RE: Legacy Home Health – 3610 Bosque Plaza Lane NW
Grading and Drainage Plan
Stamp Date: 11/02/17
Hydrology File: E12D006F

Based upon the information provided in your submittal received 11/09/2017, the Grading and Drainage Plan **is not** approved for Site Plan for Building Permit. The following comments need to be addressed for approval of the above referenced project:

8 RIP RAP SWALE SECTION

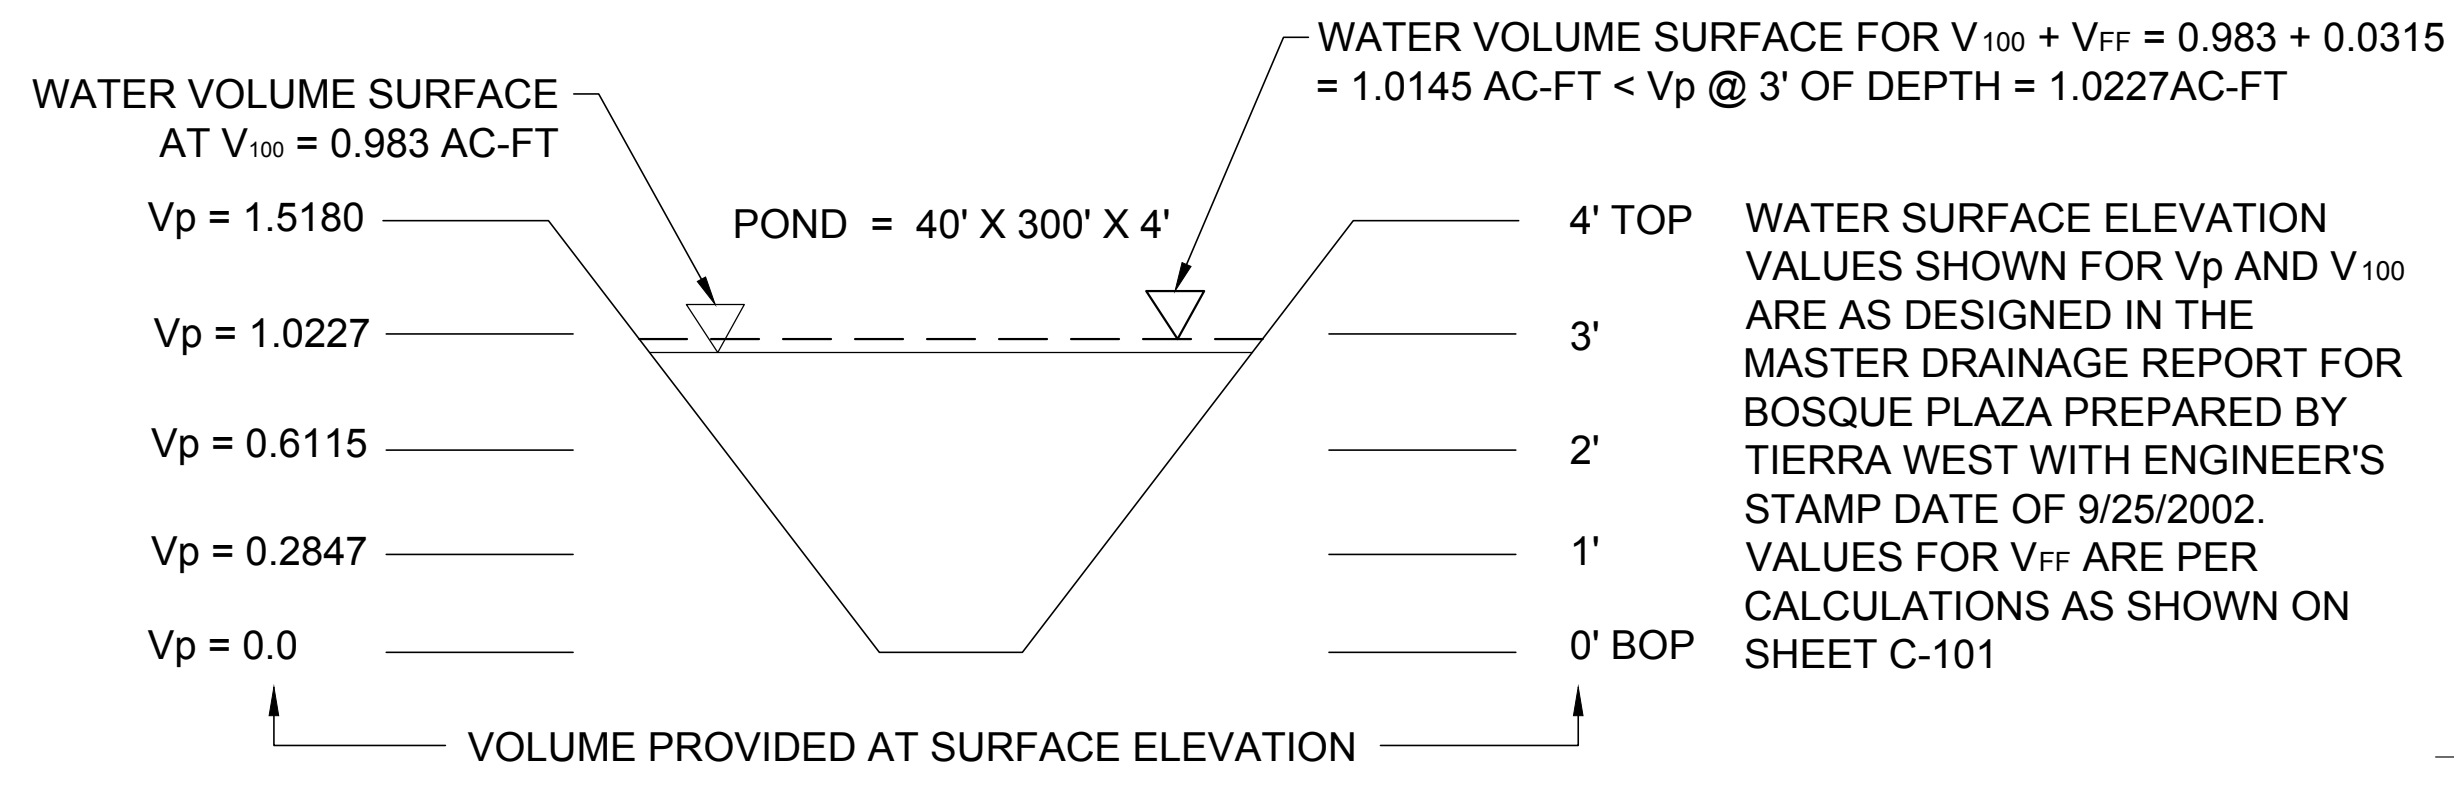
3. Please provide the weir calculations for the curb cut.
4. Please provide a cross section detail of the proposed riprap.
5. To prove the capacity of the first flush volume in the existing detention pond, please provide a cross-section showing the 100 year water surface elevation as designed in the Master Drainage Report for Bosque Plaza prepared by Tierra West with engineer's stamp date of 9/25/2002. Then show that there is additional capacity for the first flush volume.
